PERSIMMON HOMES
NORTH LITTLEHAMPTON PHASE 2
B3/B5 ACCESS ROAD

STAGE 1 SAFETY AUDIT - ADDENDUM

Project Code:	S/PHLITTLE-P2.1B.6a
Prepared by:	Ken Fry
Approved by:	John Reid
Issue Date:	29 April 2016
Status:	FINAL

Title: B3/ B5 Access Road
General Arrangement
Sheet 1 of 2

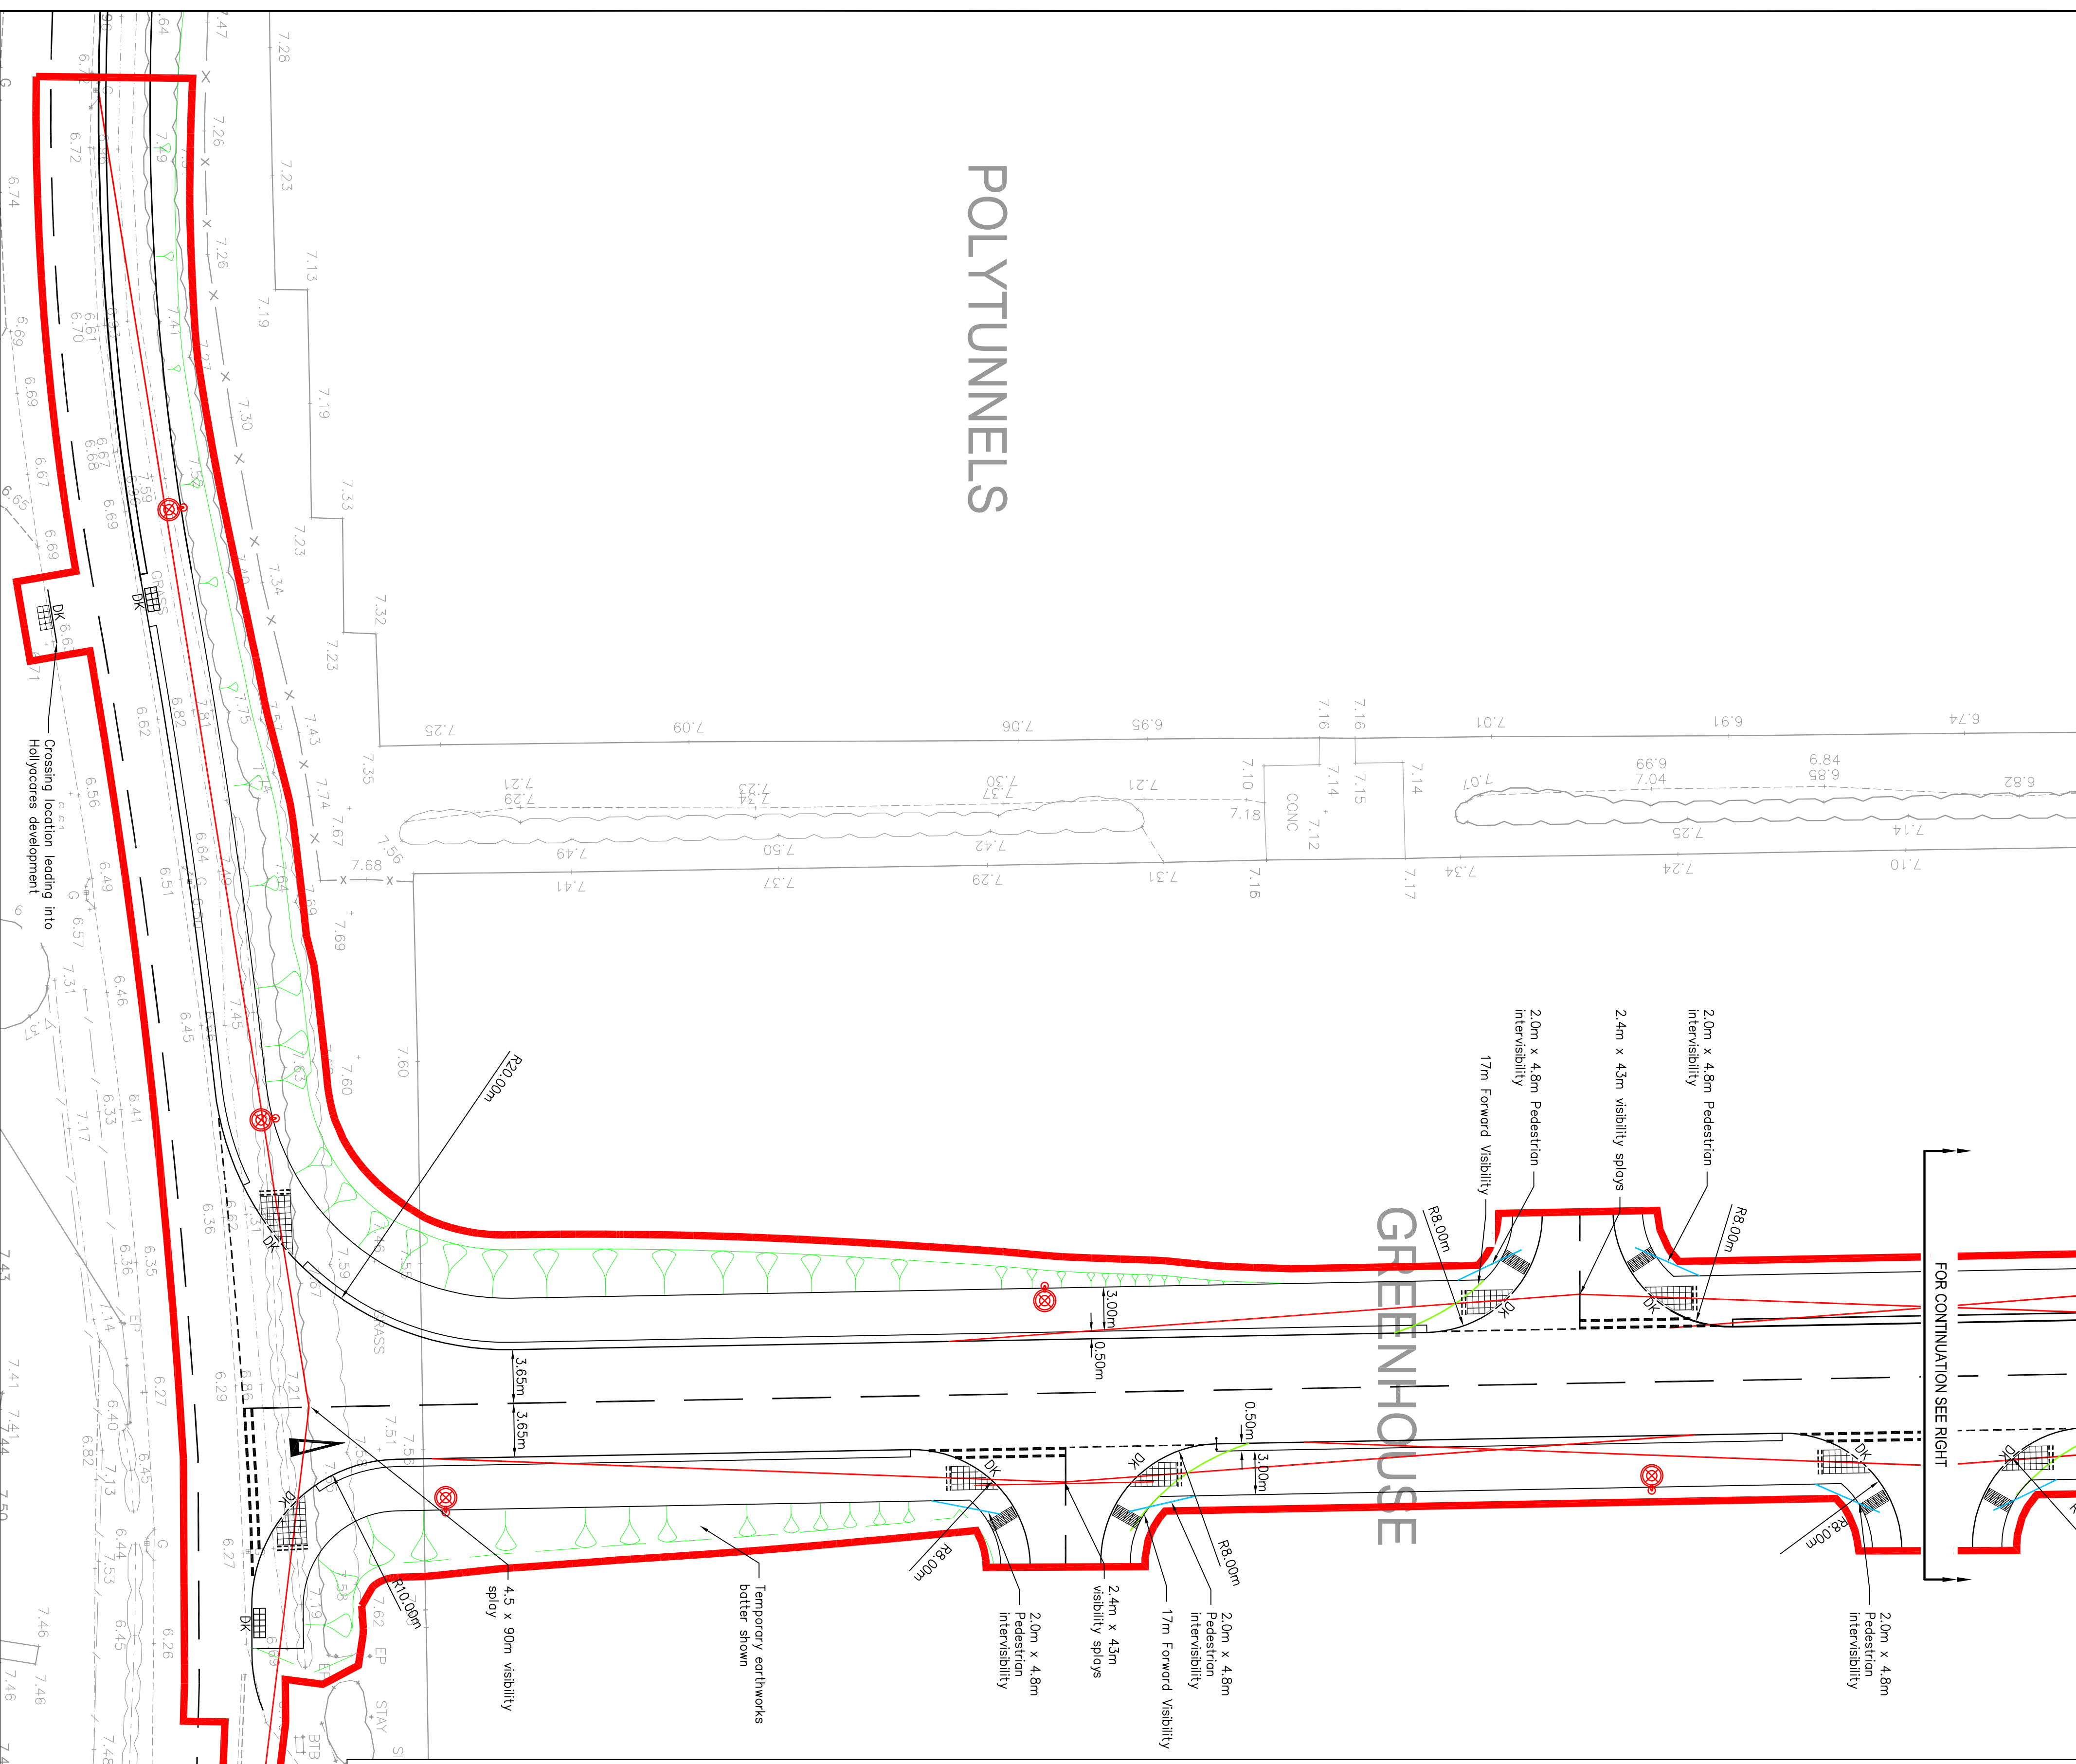
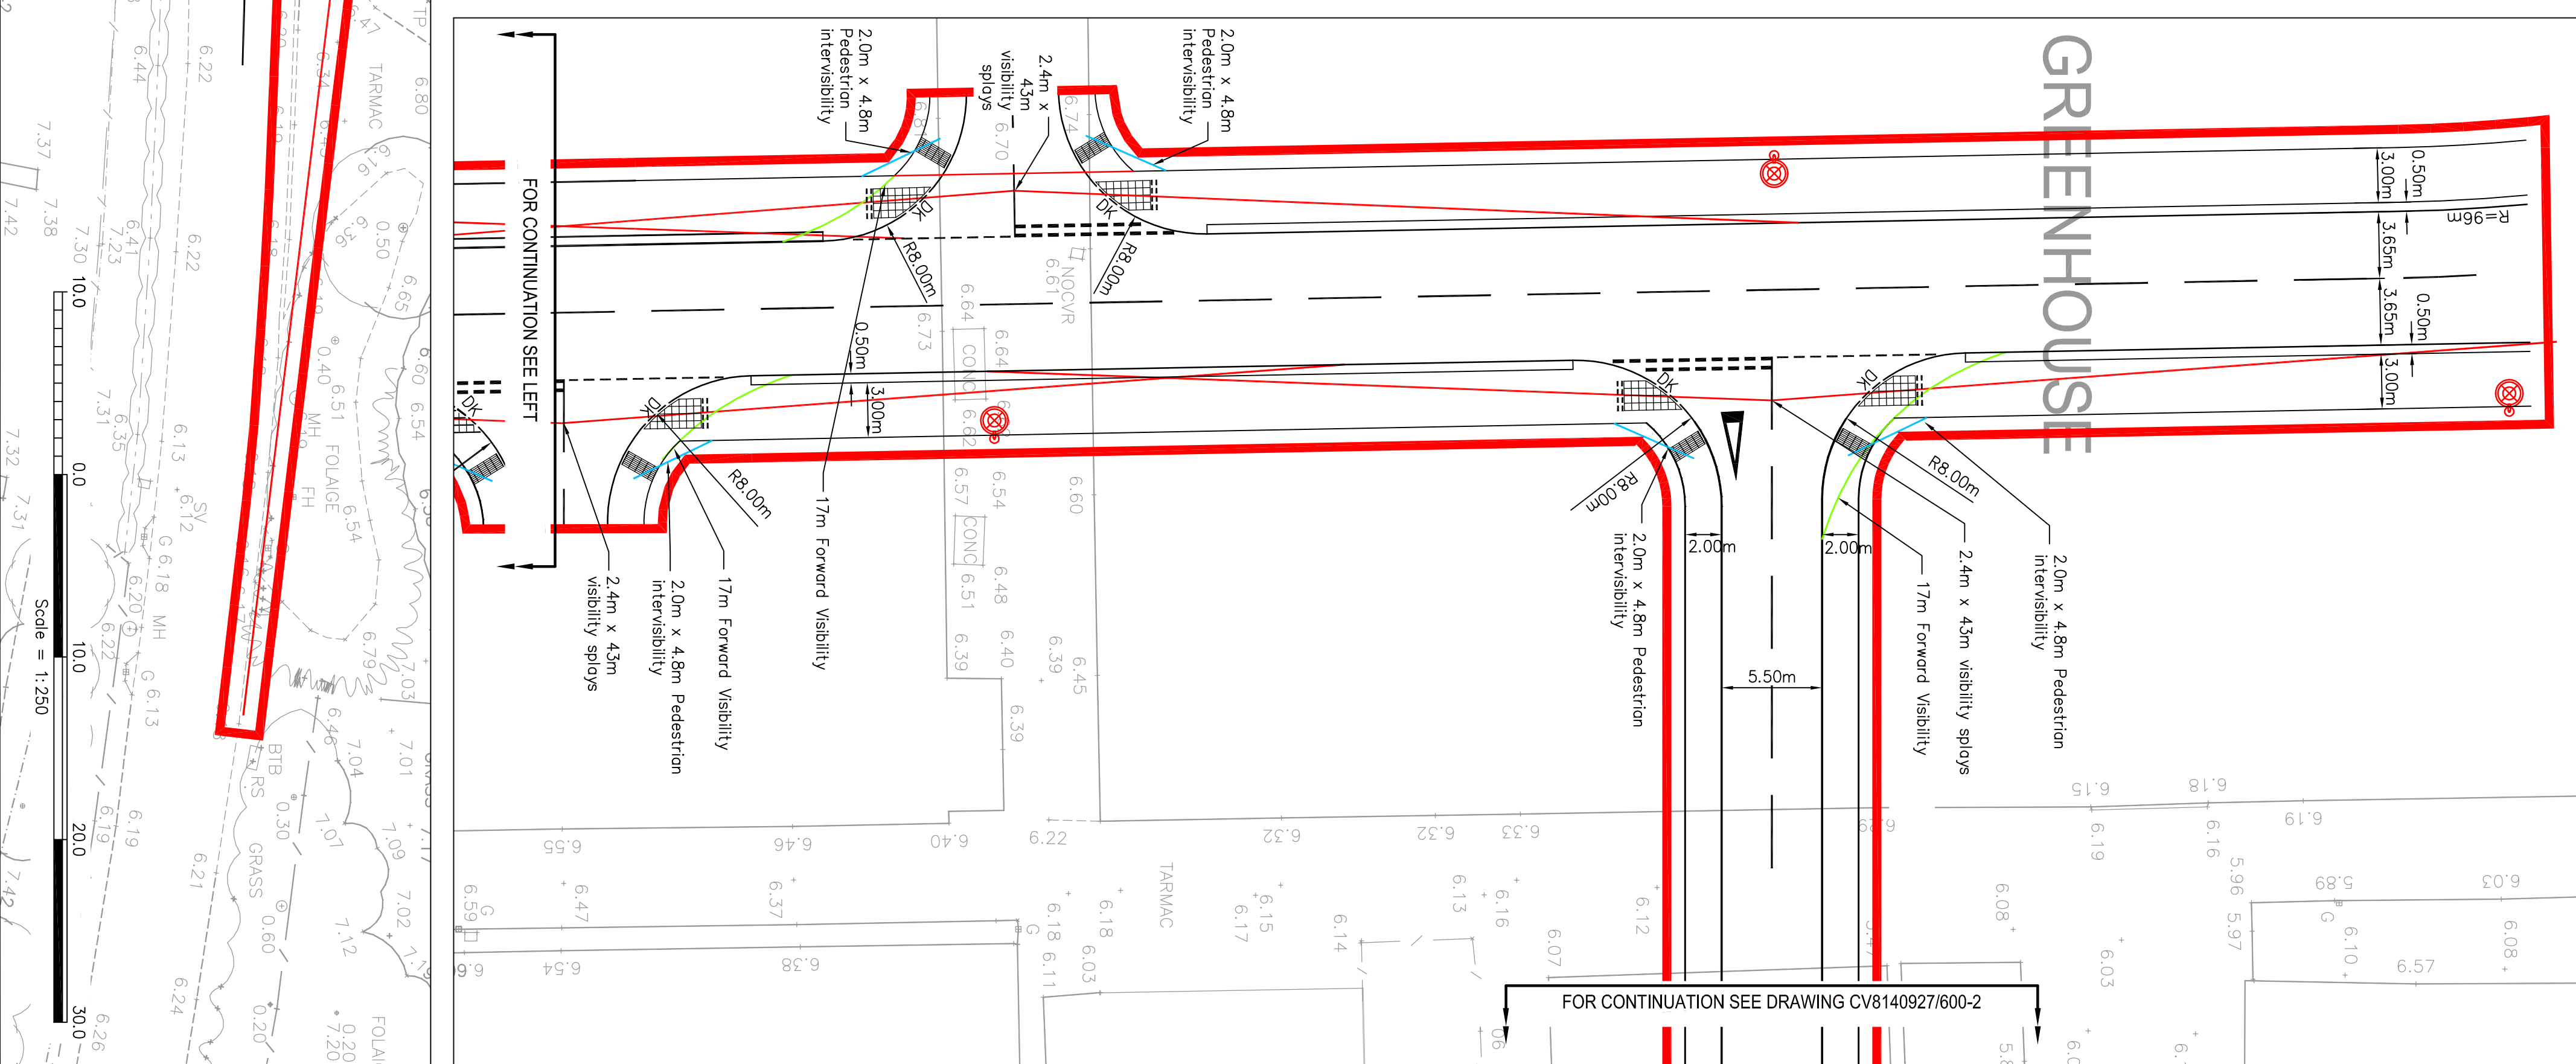
The drawing shows a 20m kerb radius on the west side of the junction. This could encourage relatively high speeds by left-turning vehicles, particularly cars and light vans, and it increases the width of carriageway to be traversed by pedestrians crossing the junction; both of these factors increase the danger to pedestrians from turning vehicles. Whilst it appears from the traffic flow information supplied in the Audit Brief that a significant number of HGVs will use this junction, it is clear from the swept path plots that the radius could be reduced without causing them difficulty.

A considerable number of trees is shown within the verges on both sides of the IDR, some of which are within designated junction visibility splays. Whilst we note that the trees are intended to be of relatively small girth and have clear stems, they will inevitably have some impact on sightlines; this effect will be greater the closer they are to the junction and will increase with time as the trees grow. This will increase the risks of vehicles emerging from the side roads being struck by passing traffic, and of cyclists approaching a junction along the shared path being concealed from drivers intending to turn into the side road.

Whilst the shared path provision should increase cyclists' safety by removing them from the carriageway, this benefit is likely to be largely nullified by the frequent interruption of the route by side road junctions where cyclists are not given priority; in these circumstances, although children may cycle along the path, confident cyclists are more likely to remain in the carriageway to avoid the possible need to keep stopping. In addition, the side road junctions are drawn with 8m kerb radii, which will not significantly reduce turning vehicle speeds to maximise the safety of pedestrians and cyclists. In accordance with Manual for Streets advice it would be better in most cases to keep kerb radii to a minimum and accept that larger vehicles will occasionally need to cross into the opposing lane of the IDR to make the turn. The Auditors have not been provided with details of the individual

- i. Reduce the kerb radius as far as possible consistent with providing adequate turning space for the largest vehicles regularly using the junction.

- ii. Inset the pedestrian crossing point slightly further into the junction (c.1.5m) to reduce the crossing width for pedestrians, particularly those with a disability, and increase their visibility to/from southbound vehicles approaching on the IDR.

Do not plant trees within the visibility splays.

Reconfigure the side road junction treatment (providing cycle priority if possible) to improve continuity of the cycle route.
